Application: SSI 7485

I write regarding the proposed modification to M4-M5 Link, Mod 2 The Crescent overpass and changes to pedestrian infrastructure in North Annandale, Rozelle and Rozelle Bay Foreshore area. *I object to the overpass and to the relocation of the GreenLink and*

Figure 4-4 Elevation: Indicative view of The Crescent overpass

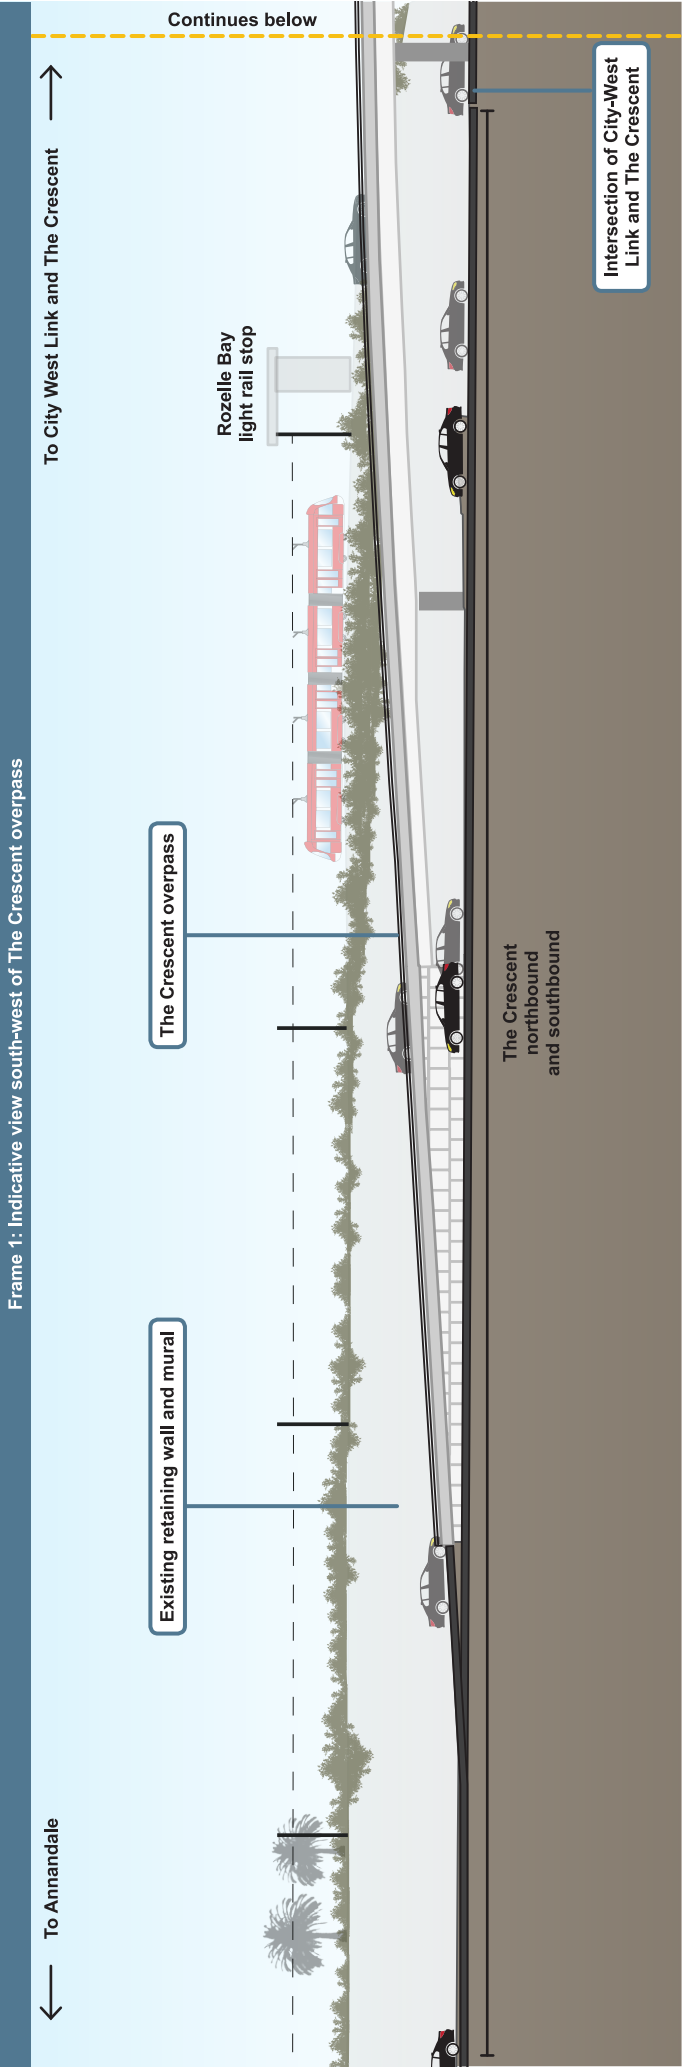
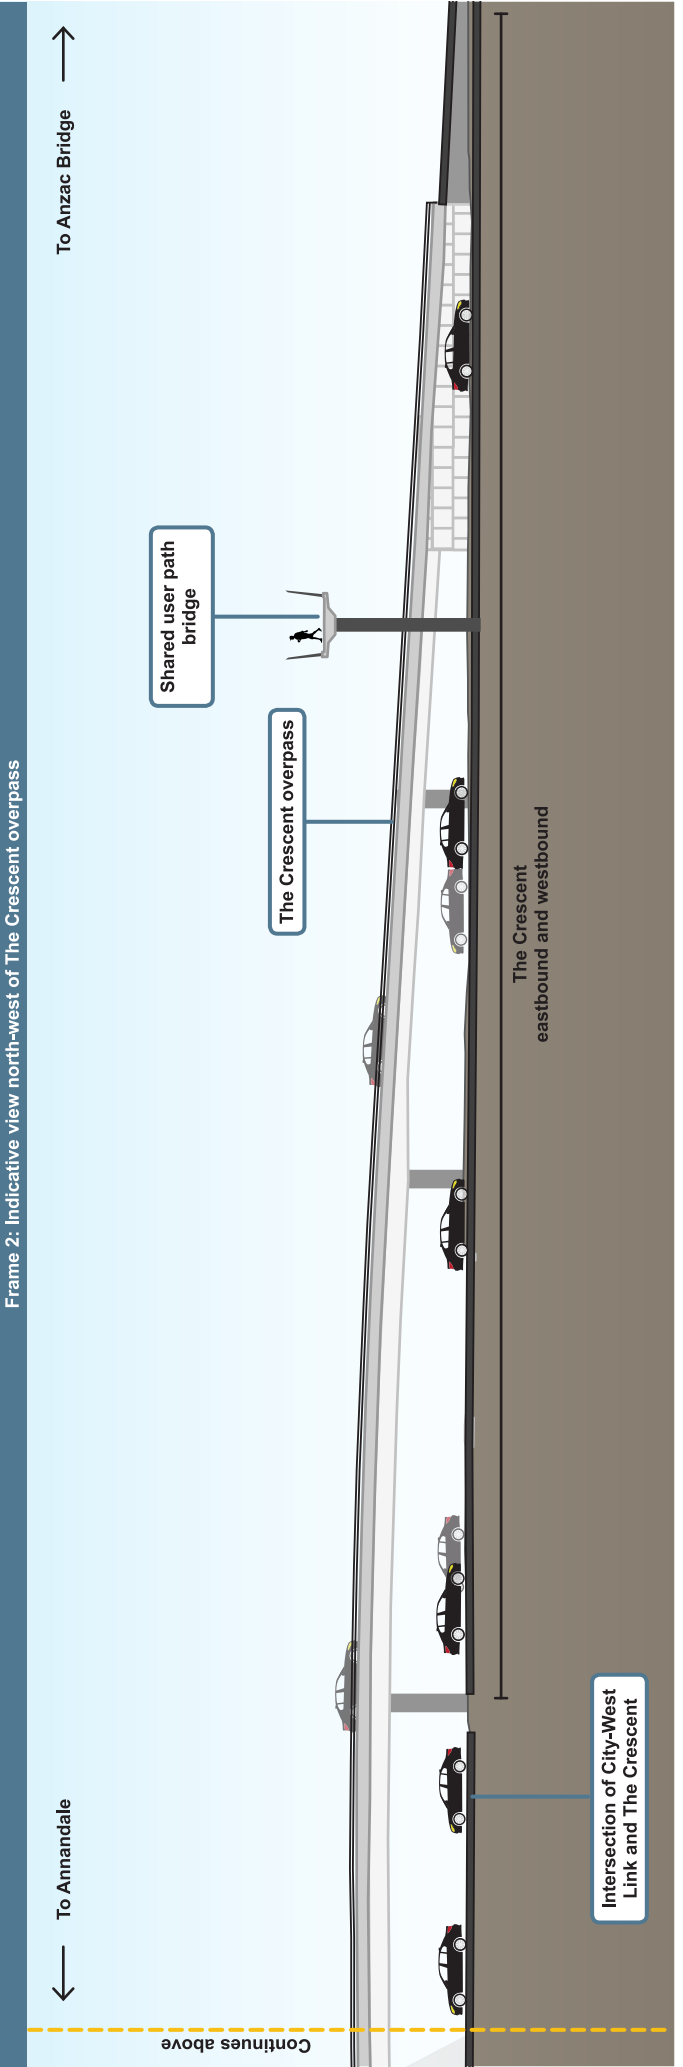
- The significantly reduced safety and increased risk for pedestrians and cyclists with removed access over The Crescent to Bicentennial Park and the increased traffic along Johnson Street.
- Being required to cross five sets of pedestrian lights at The Crescent as my option to reach the foreshore from Annandale or from Rozelle Bay light rail stop.
- Removal of direct active links to the foreshore, cutting the community off from the area and the proposed revitalisation of the entire Bays Precinct, including linking the Light Rail and Bus stops to a Ferry wharf and Metro station.
- Urban and landscape design that is being built before a finalised Masterplan for the area.
- Traffic changes that limit movements around the suburb and create further congestion in the local streets of Annandale, Forest Lodge, Glebe, Lilyfield and Rozelle with no planning to deal with these.

- **Respond to the local character** Respecting and maintaining the unique heritage, industrial character and topography of the Rozelle Rail Yards through interpretation. **A massive concrete overpass obstructing a historically significant local mural and concrete plaza — really?**

Figure 4-5 The Crescent/Johnston Street/Chapman Road intersection

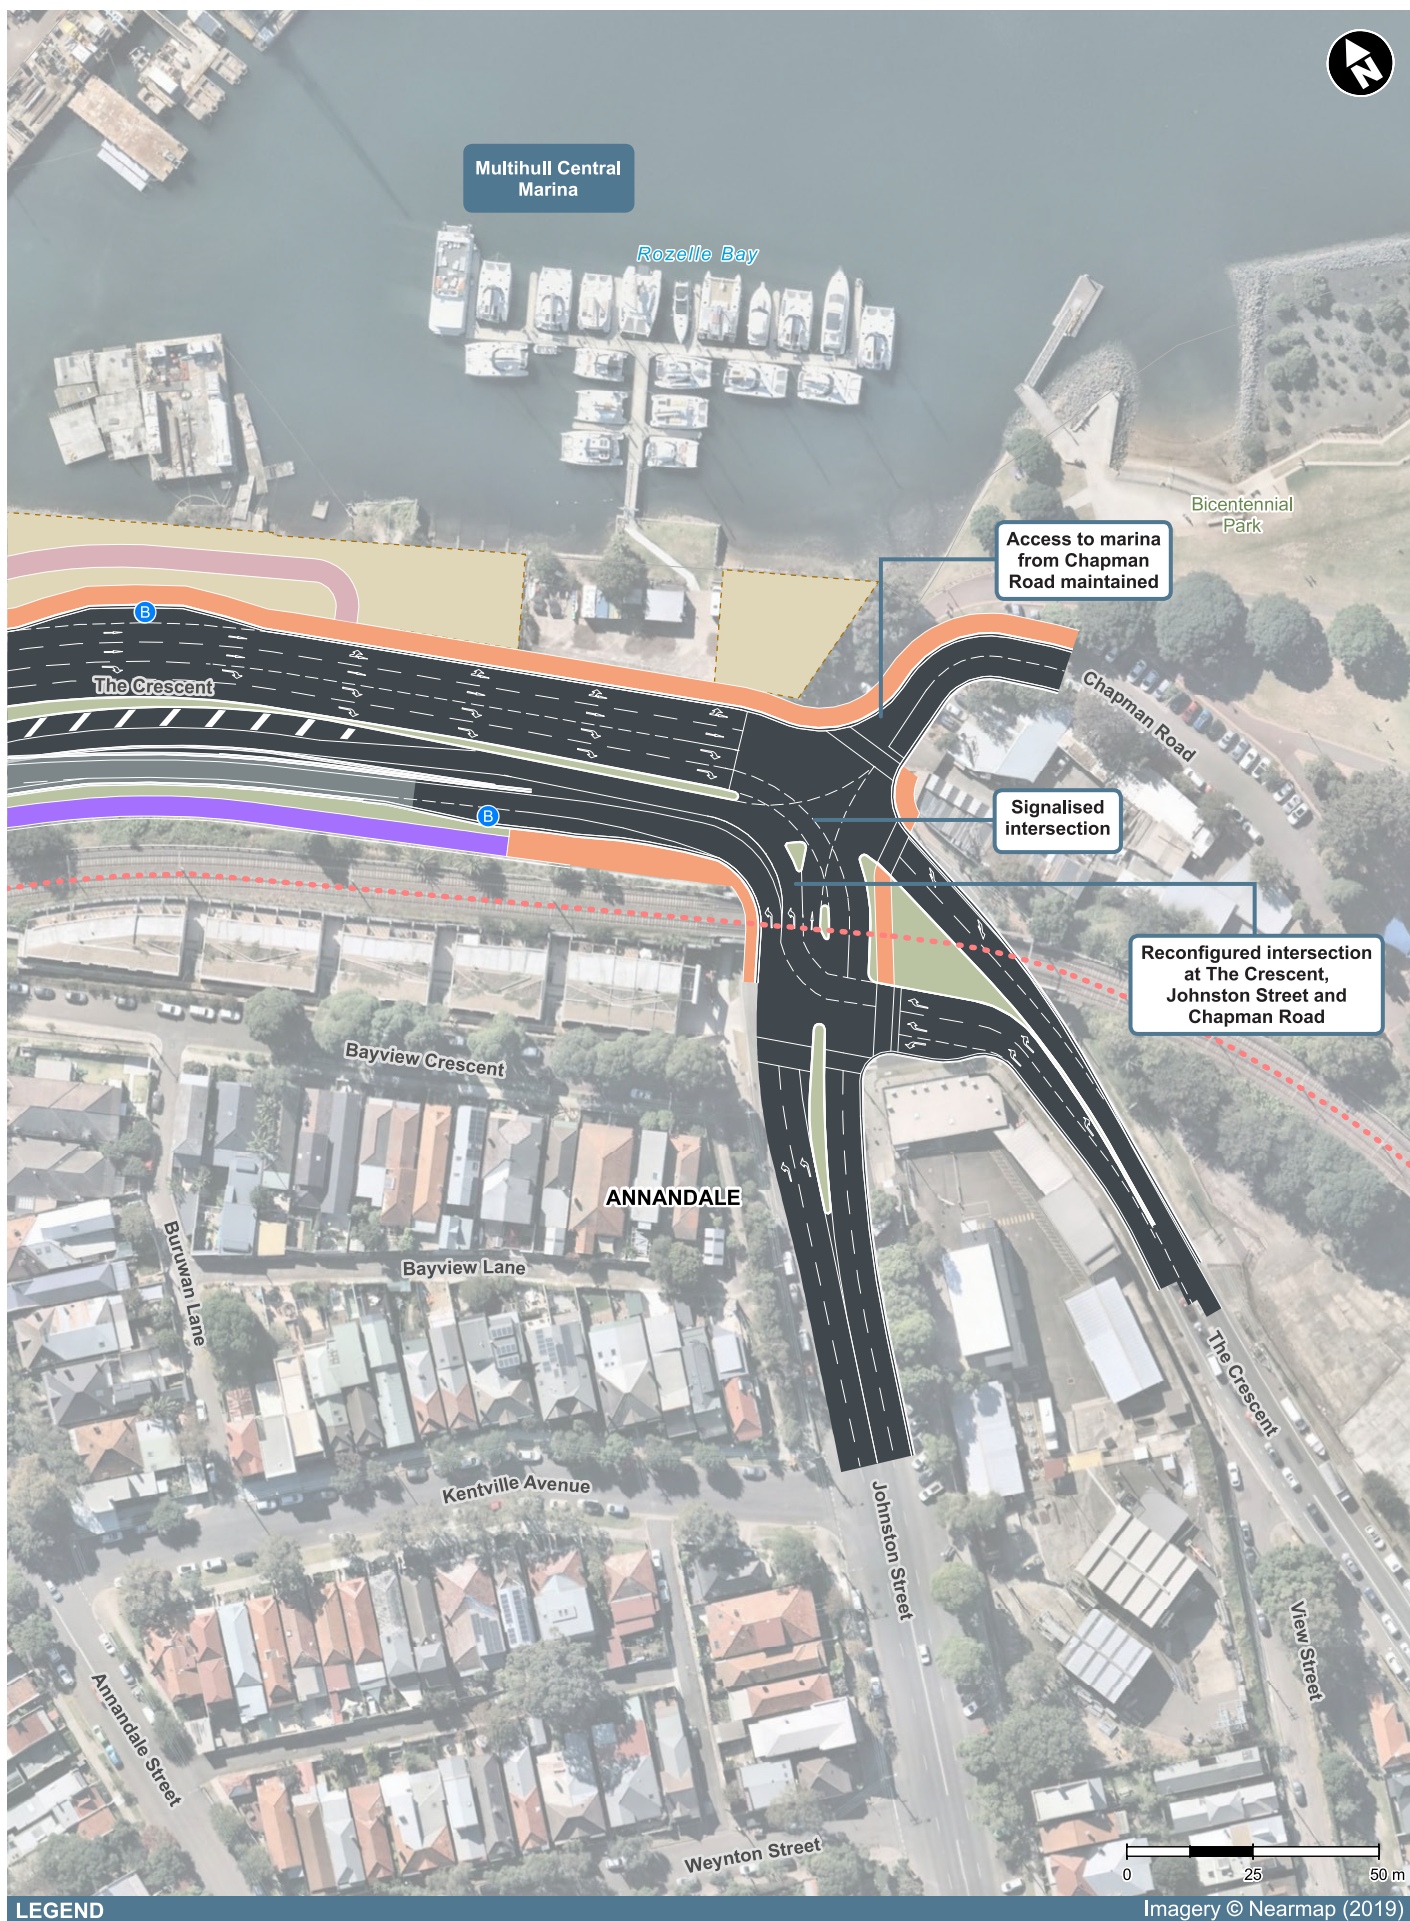
Re-design pedestrian and cycle access from Johnston Street to the harbour foreshore. Pedestrians should not have to cross 4 roads in order to access this area. The design should prioritise active and public transport over cars. This is healthier for communities and people.

Figure 4-6 Elevation: Indicative view of Rozelle Rail Yards Pedestrian and Cycling Green Link

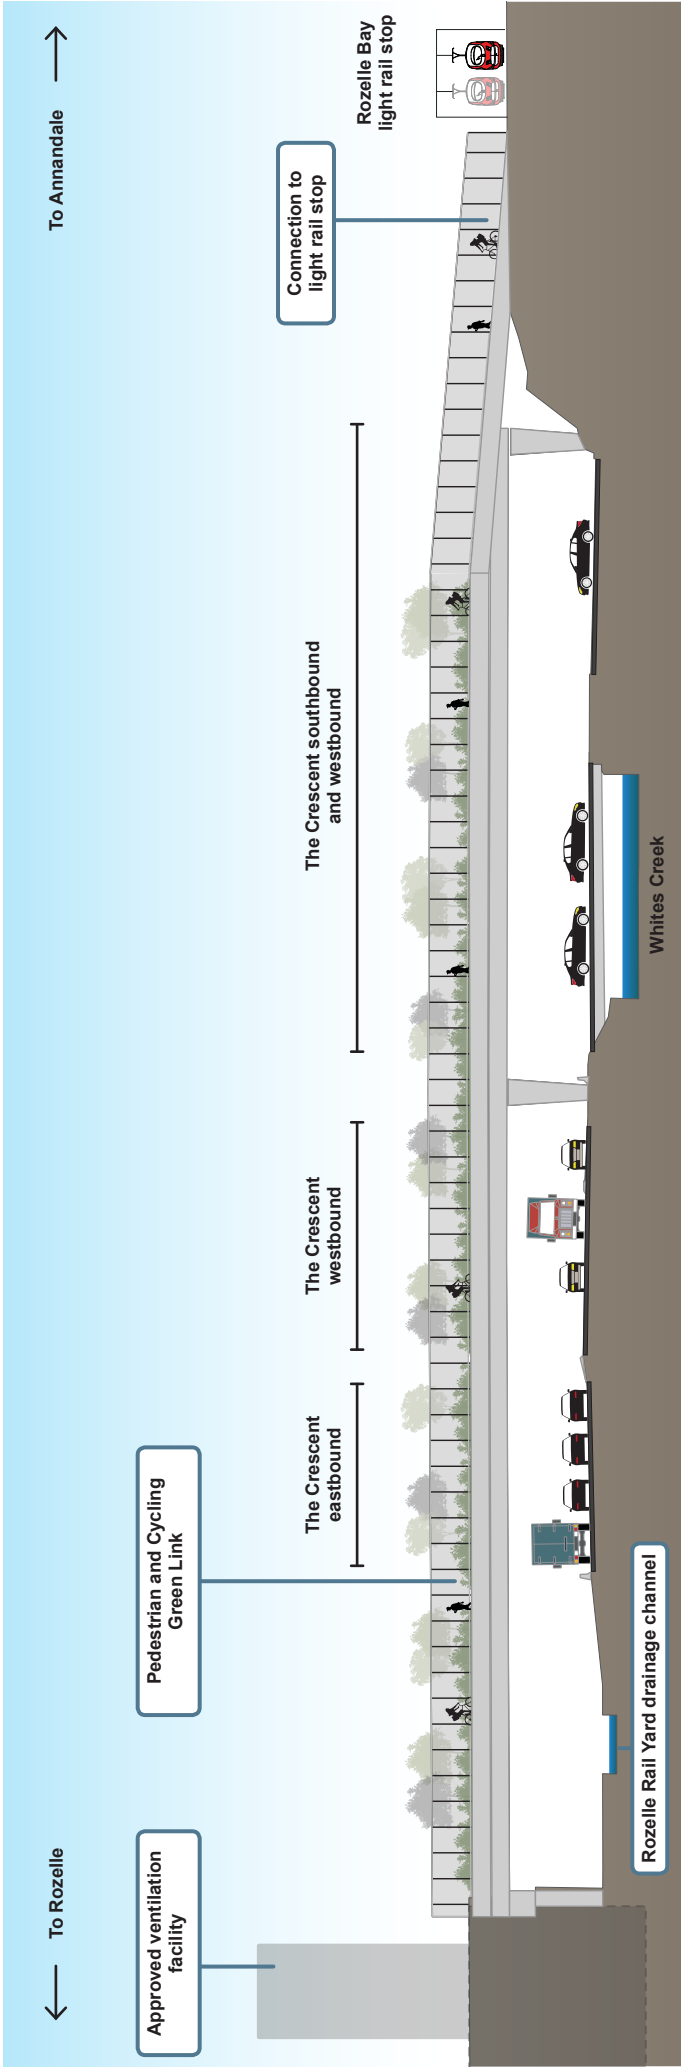
I request RMS work with the community to explore alternate design options to the proposed new car overpass design and the changed pedestrian and cyclist links. I am seeking the reinstatement of the safe, direct access from the approved EIS GreenLink to create a continuous green open space connection from the Rozelle Rail yards and Annandale to the foreshore.

- **Enhance green links** The concept reactivates closed-off land through new green spaces and links. These links strategically establish a new green "interaction" connecting a series of significant yet fragmented [future and existing] green spaces in and around White Bay, Rozelle Bay, Rozelle, Balmain, Glebe and Annandale. **MOD 2 removes direct access**

- Reinststate the GreenLink connecting communities and green open space from Rozelle to Bicentennial Park
- Relocate and design pedestrian and cyclist connections that are continuous, safe and direct.
- Design the modification infrastructure and active links in response to the character of the suburbs, the location of the foreshore and it's potential future development.
